Re: **MSR Tuscany Woods Townhomes – PA23-015**
IECO No. 22-1215

The project referenced above is revised in response to the review comments dated October 31, 2023. The review comments are numbered on the letter and have been addressed in *italics* as follows:

MSR TUSCANY WOODS
DWG FILENAME: 221215-PRELIM.DWG DESIGNED BY: JTK DATE: 05-10-2023 SCALE: 1"=40' JOB NO.: 22-1215 SHEET: S1

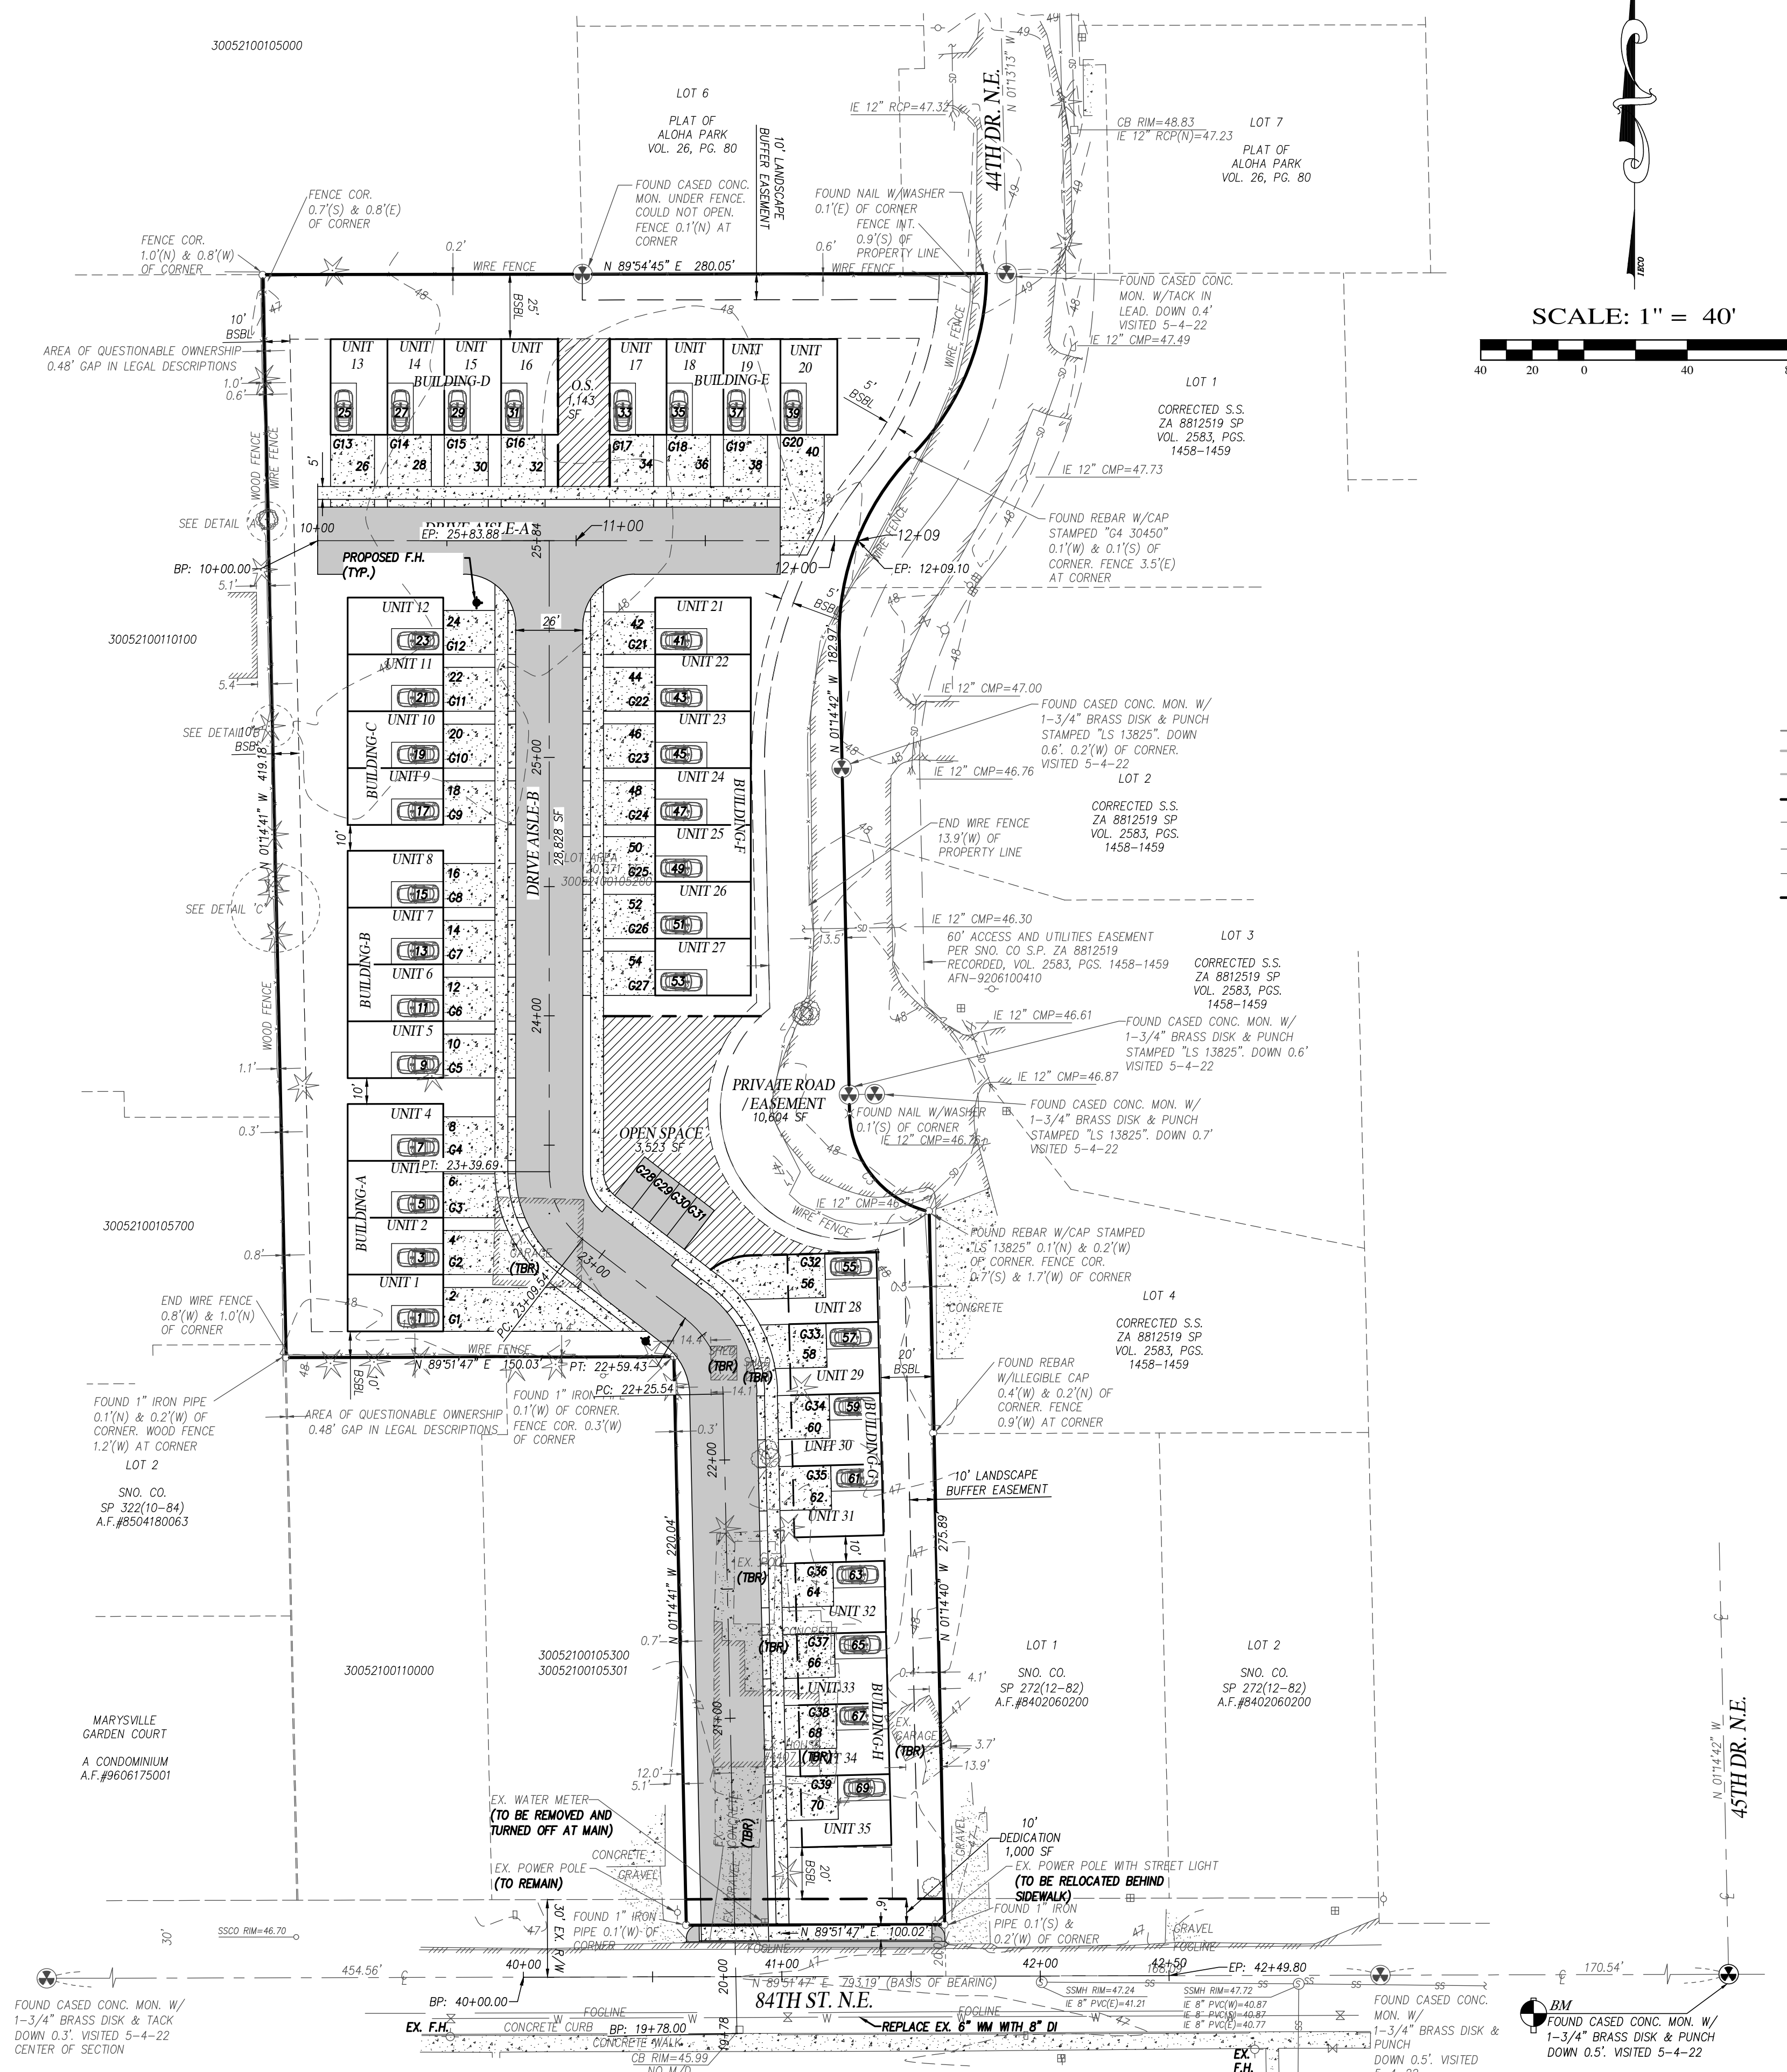
2. The proposal includes use of residential density incentives (RDI) in order to obtain seven (7) bonus units. Please identify the fencing/landscaping proposed for bonus units.

6. In order to meet parking standards, driveways shall be a minimum of 20 feet in depth. A number of the unit driveways do not appear to meet this requirement. Please review and revise accordingly.

8. The sidewalks on the south portion of Drive Aisle A effectively lead to nowhere and should be removed (see areas highlighted below).

9. There is a portion of pavement that appears to be the proposed access for unit 20 that is shown in in the private road (see area highlighted below). This is not acceptable and will need to be revised. No access from 44th Drive is permitted.

9 bonus units are proposed. The landscaping for that portion has been identified on the landscape plan, which make for 2 bonus units. In addition, fees for capital projects are proposed for 7 of the units. Please see bonus unit calculations on the site plan.

Each driveway is at least 20' deep.

The sidewalks have been removed. Please see the revised site plan.

This portion of the driveway has been removed. Please see the revised site plan.

PRELIMINARY ROAD, DRAINAGE AND UTILITY PLAN
C1

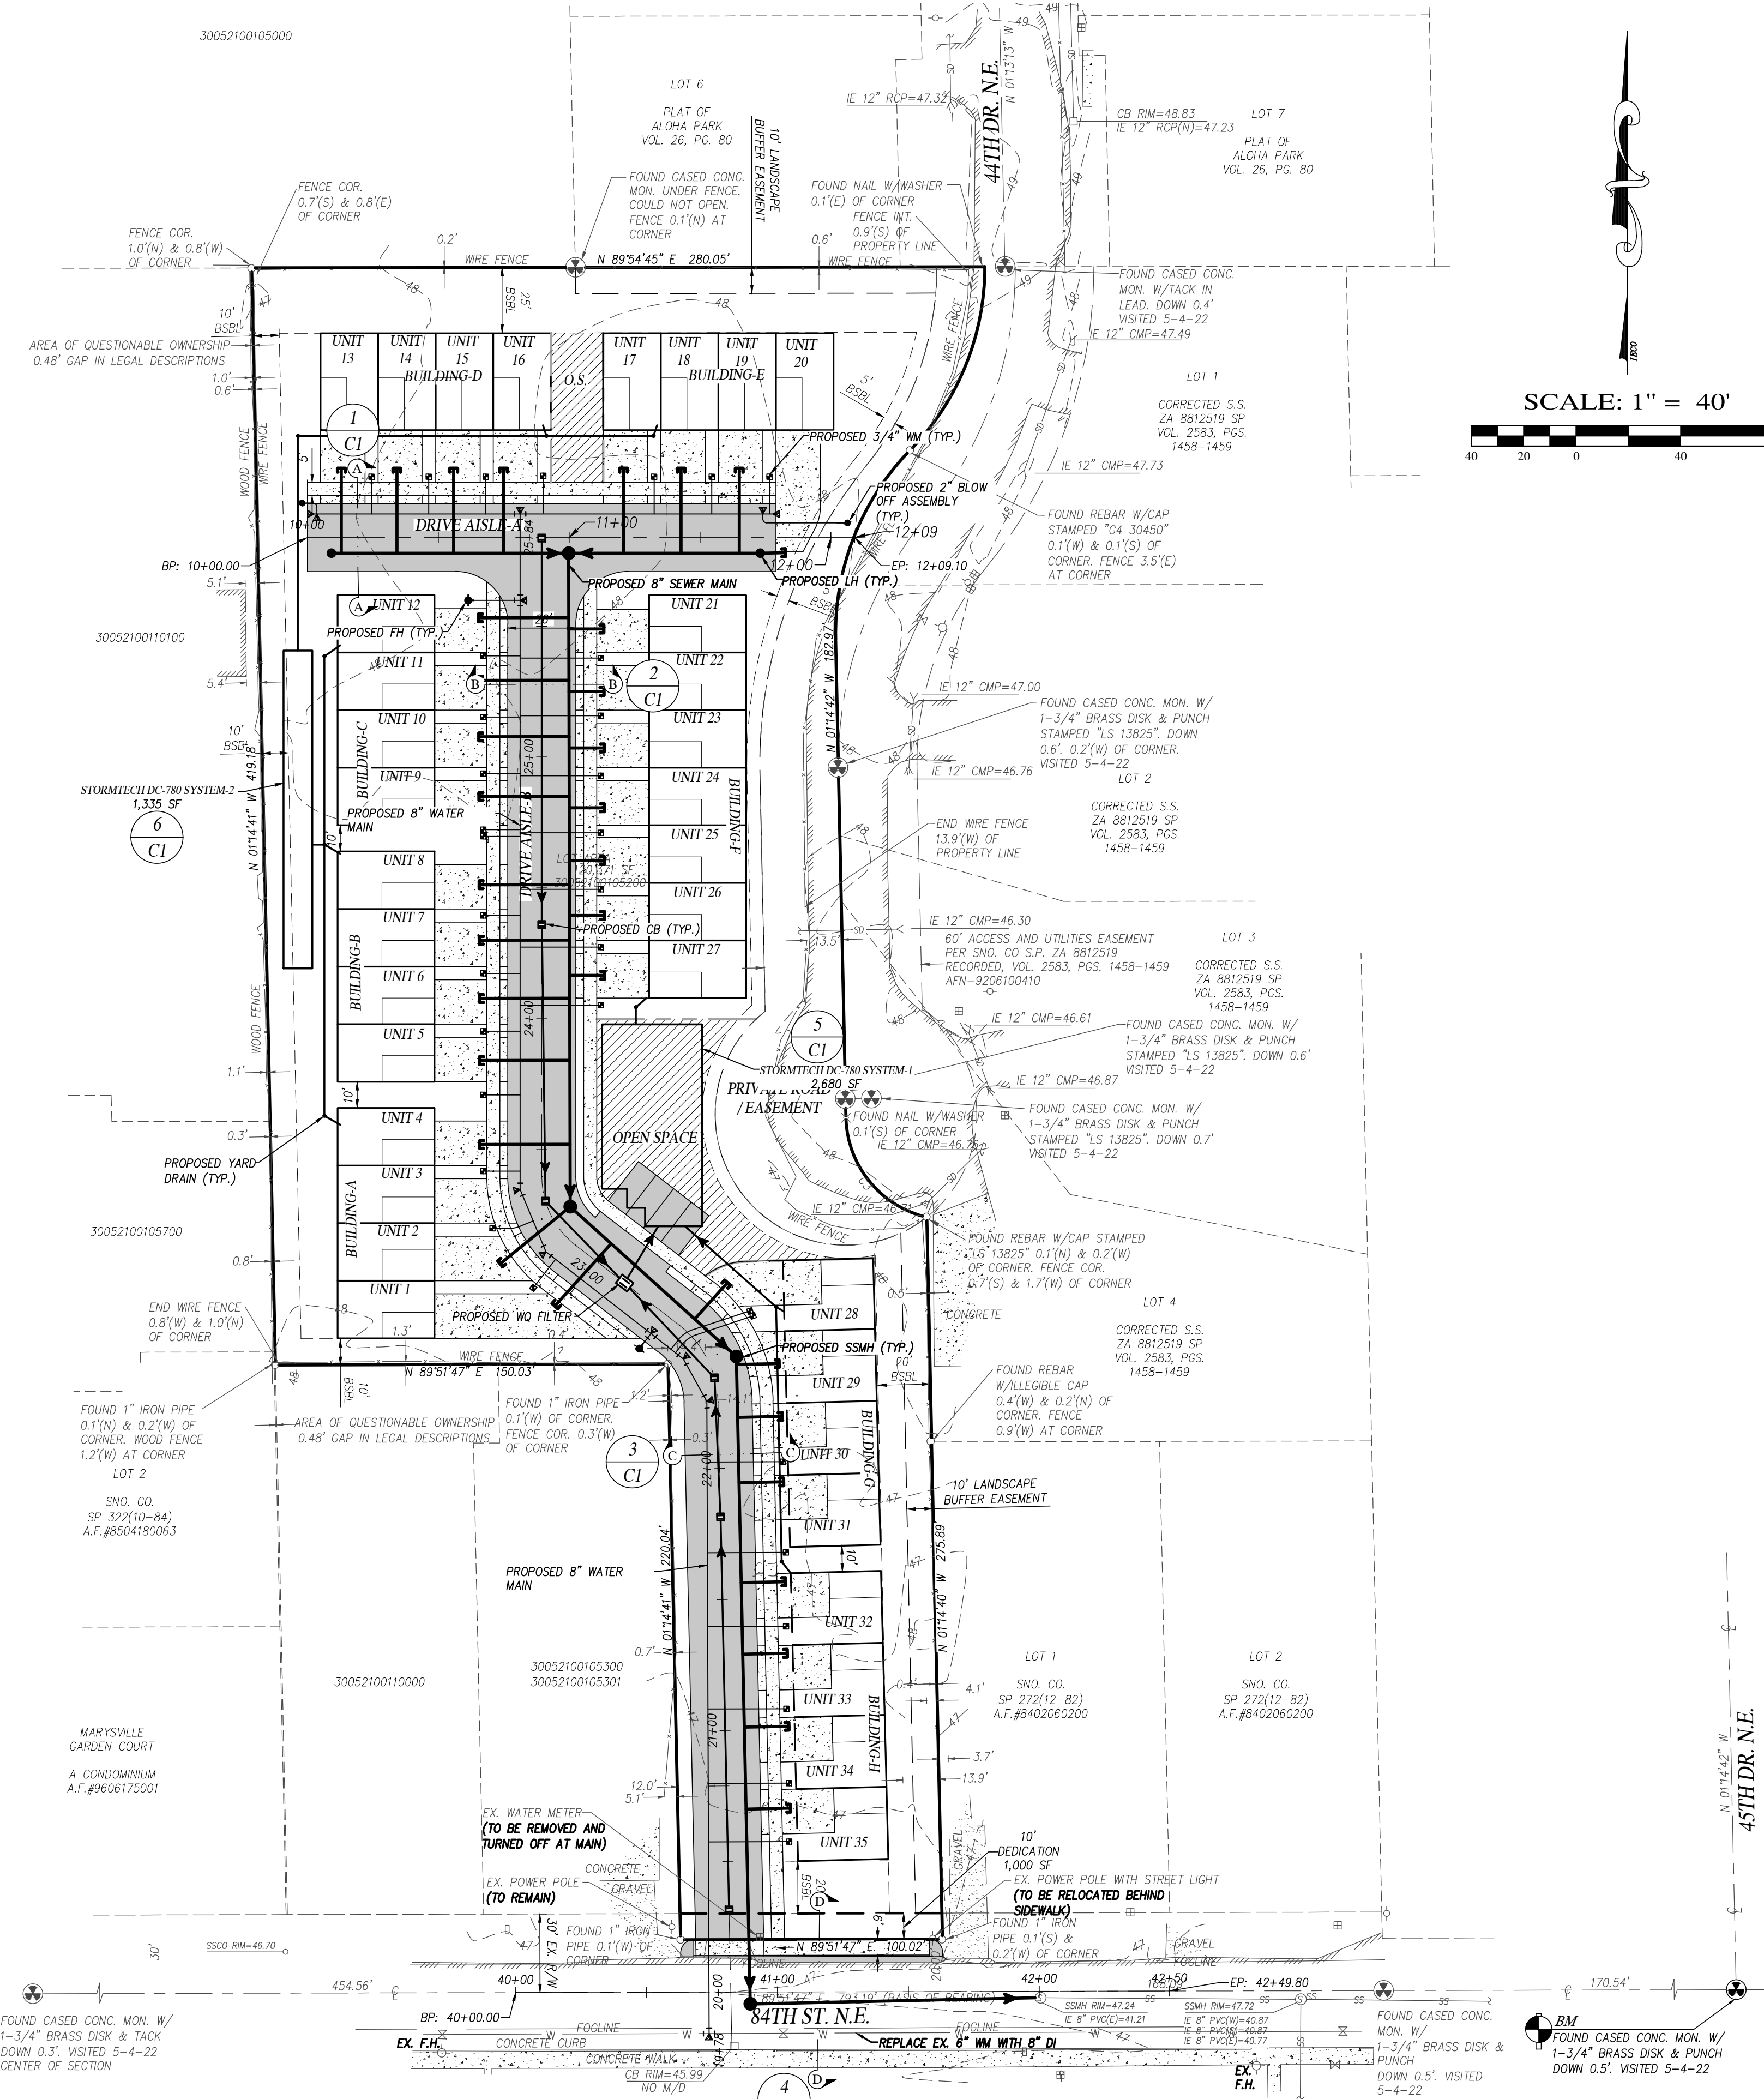
1. Drainage: All projects in the city of Marysville must comply with requirements stipulated under the MMC 14.15.040 and 14.15.050.
 - a. Please edit your drainage report to reflect using the 2019 SWMMWW. There are still references to the 2014 manual.

The Drainage Report is updated and included with this submittal.
